My ref: RLS/18.02/17/AR

Your ref: A/87/18/PL

26th July 2018

Proposed Single Dwelling: Land at the Ninth Tee, Ham Manor Way, Angmering.

Street Elevation (1:200)

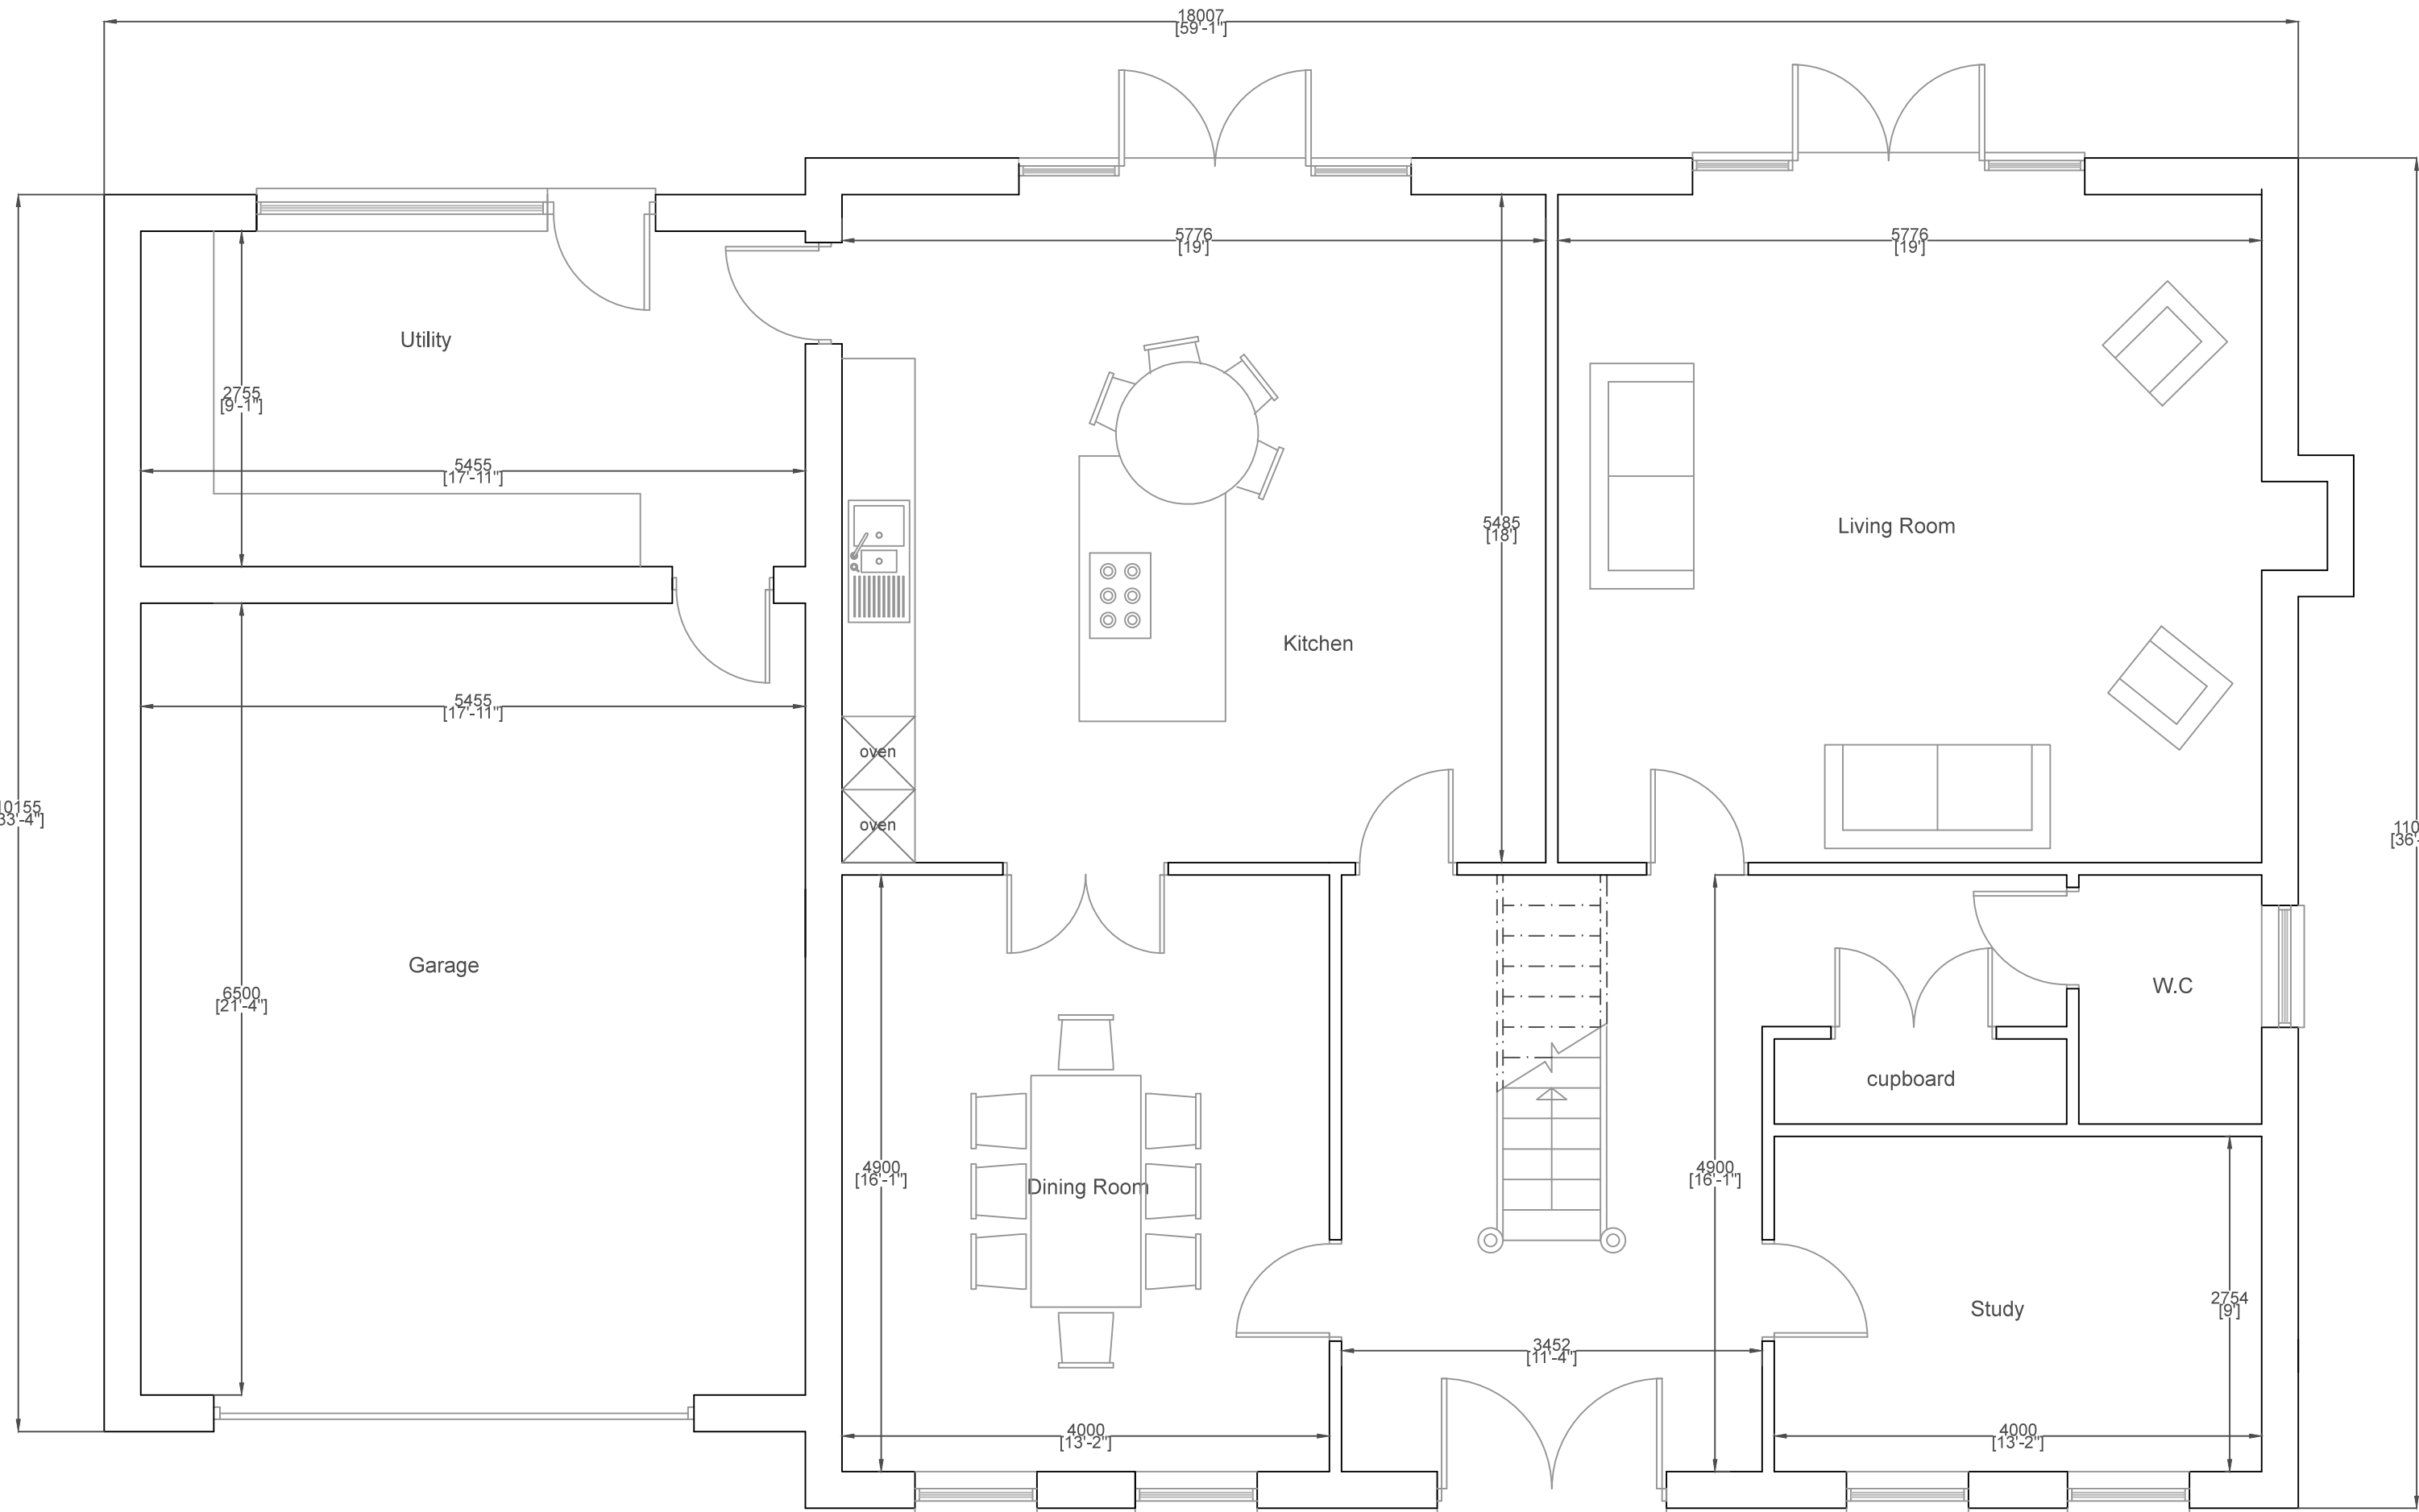
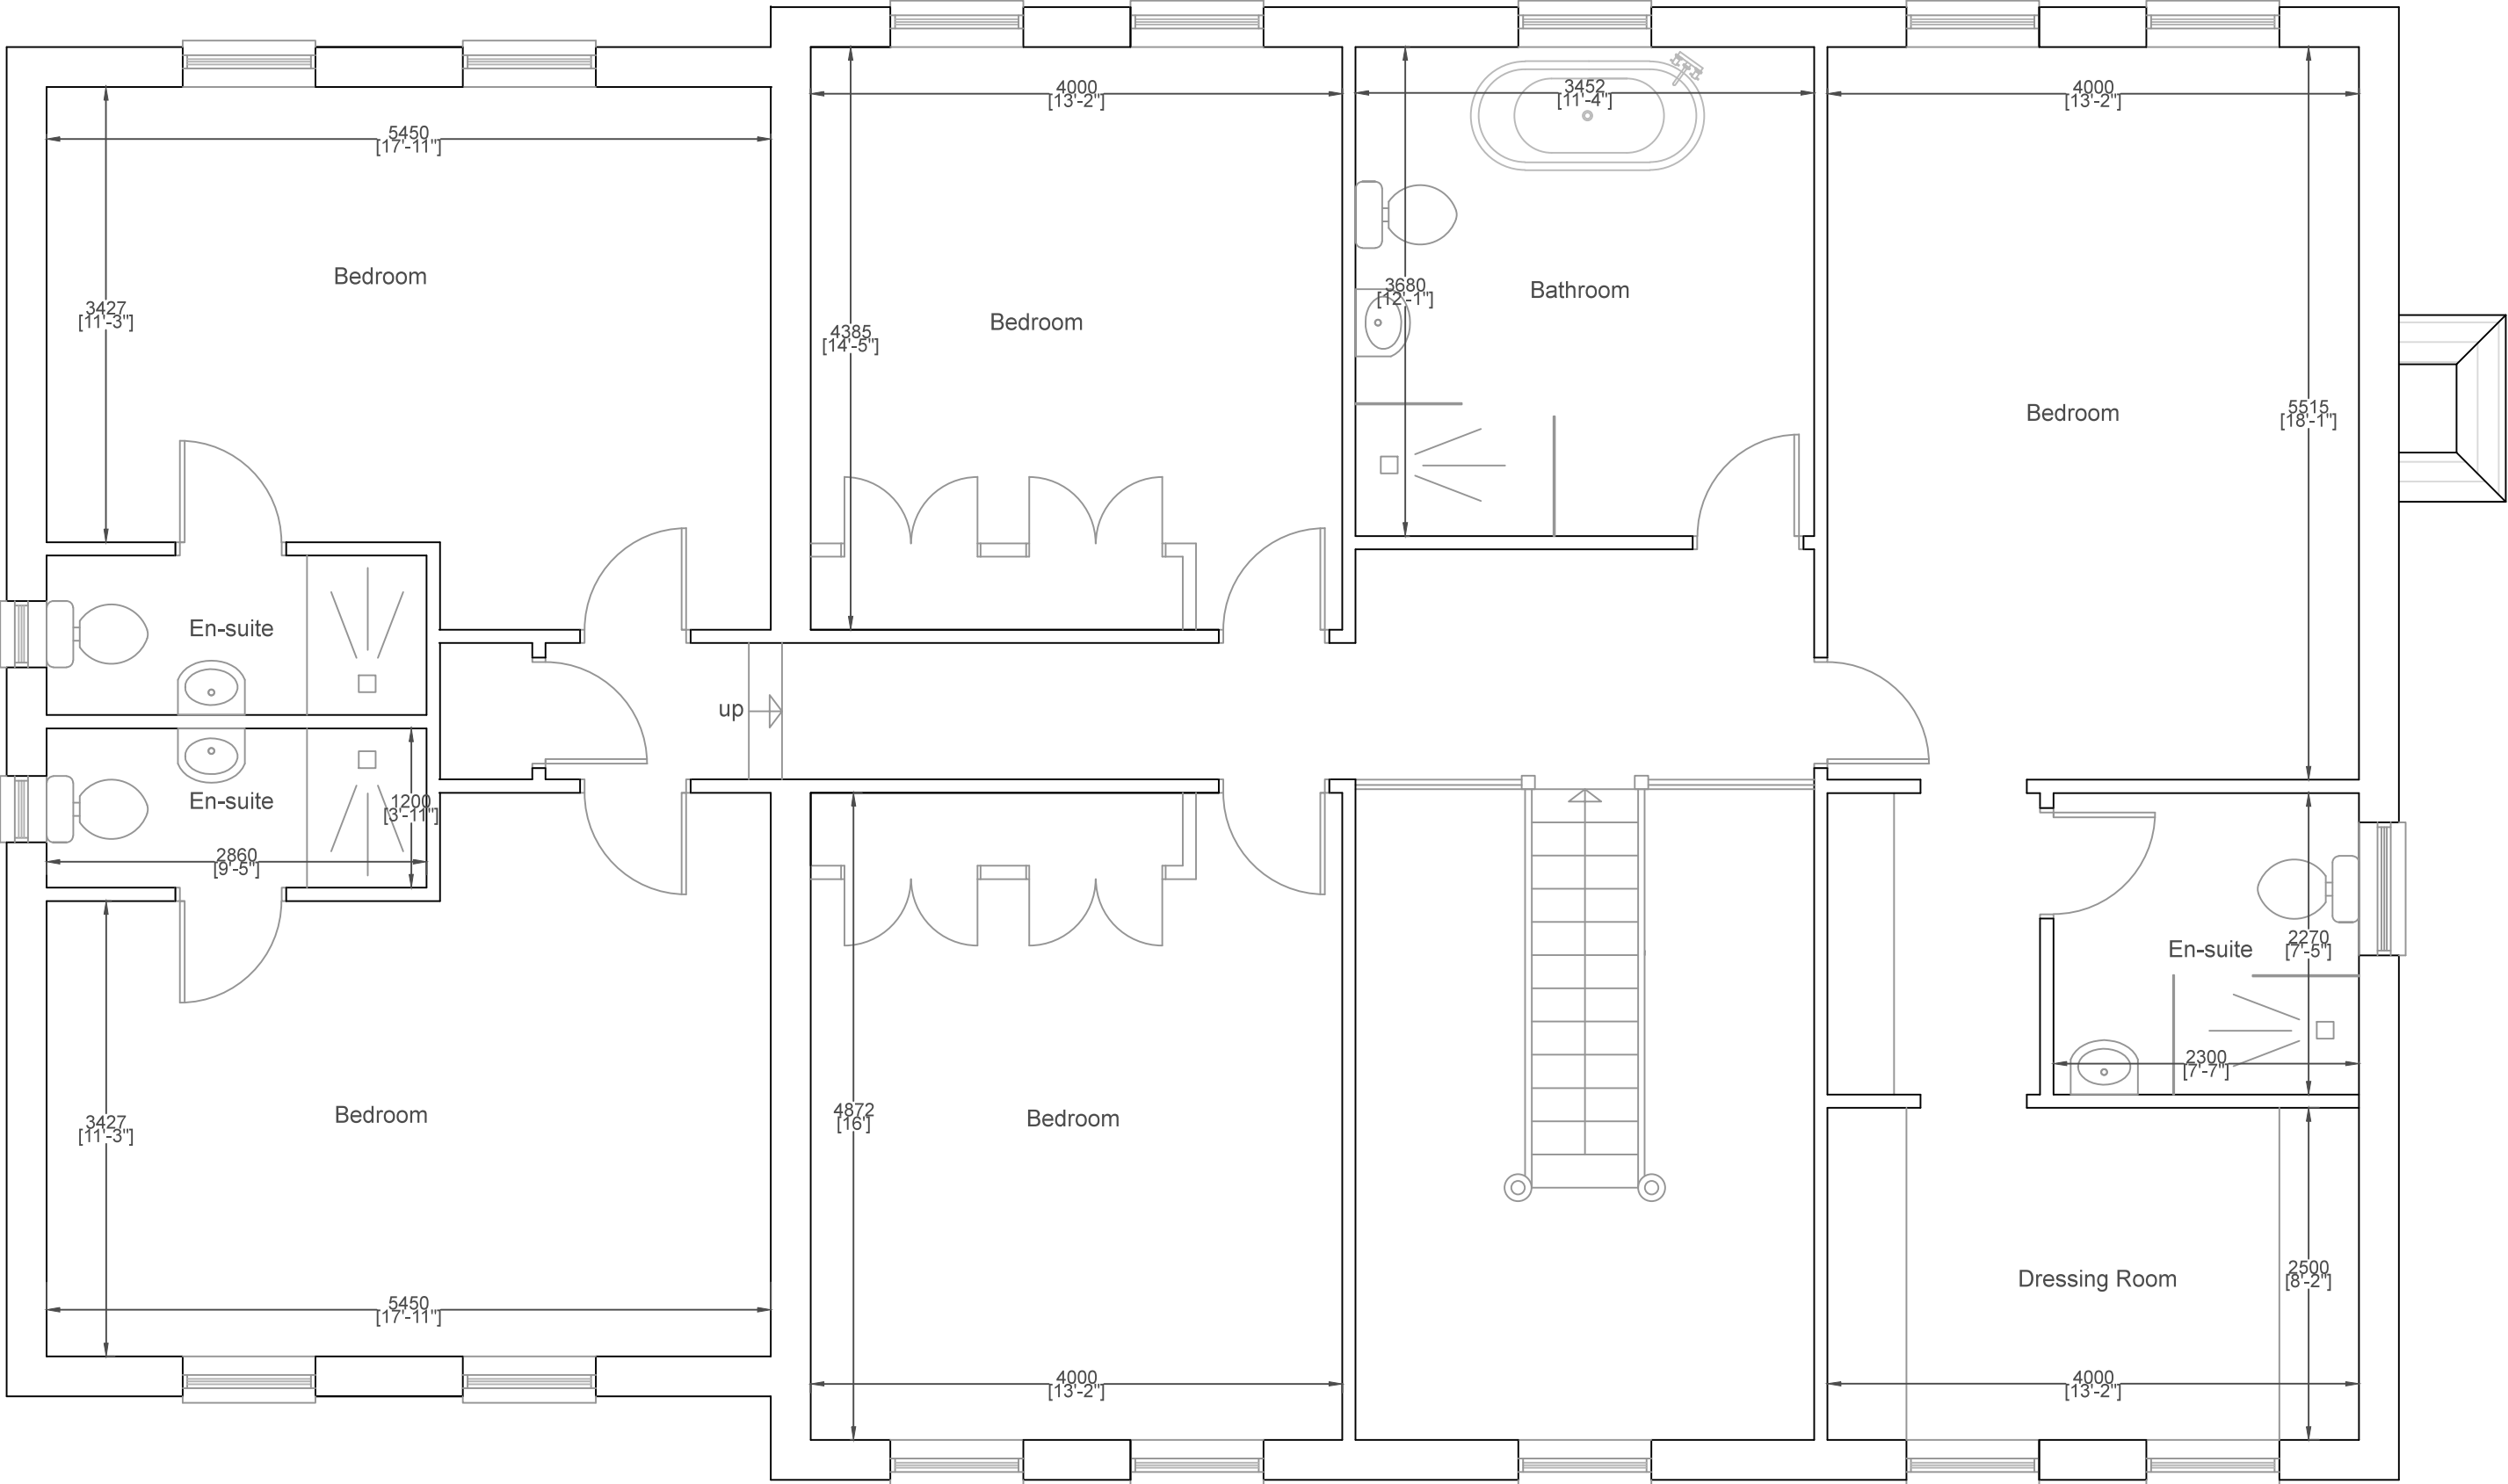
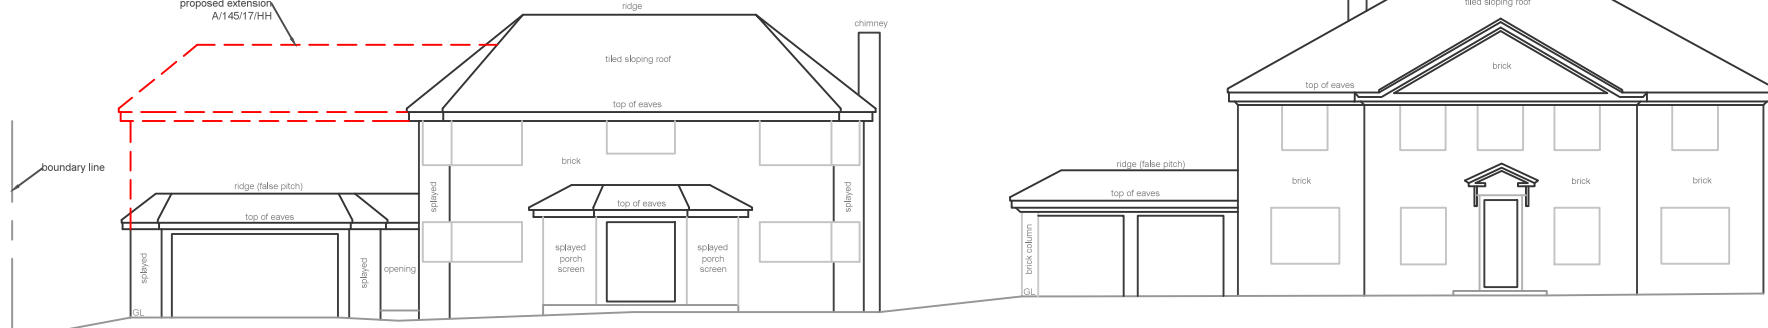
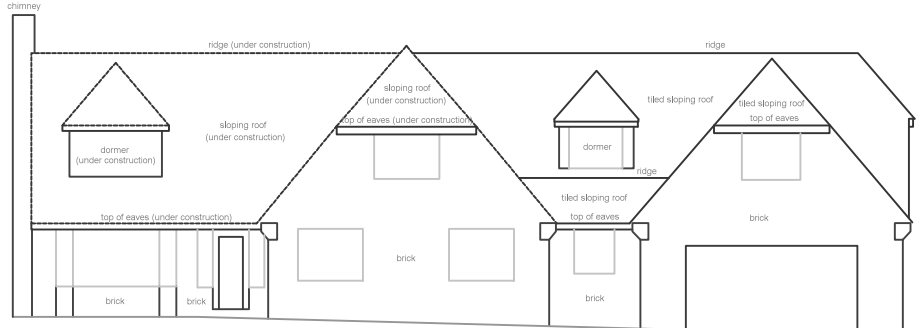
Finally, the last matter that I wish to focus on is the design of this unit. As one travels north along Manor Way the appearance of the street scene is primarily of bungalows and chalet style dwellings. I acknowledge that the design to the north contains a number of houses with a group of three to the immediate north of this site this design of unit does not fit in with the appearance of the street scene as one travels northwards along Ham Manor Way. One has to recognize that the building appears located on the lower ground level within the gap, however, it is still a substantial two-storey force of development across the frontage of the site which is larger and more prominent in style than a chalet style dwelling.
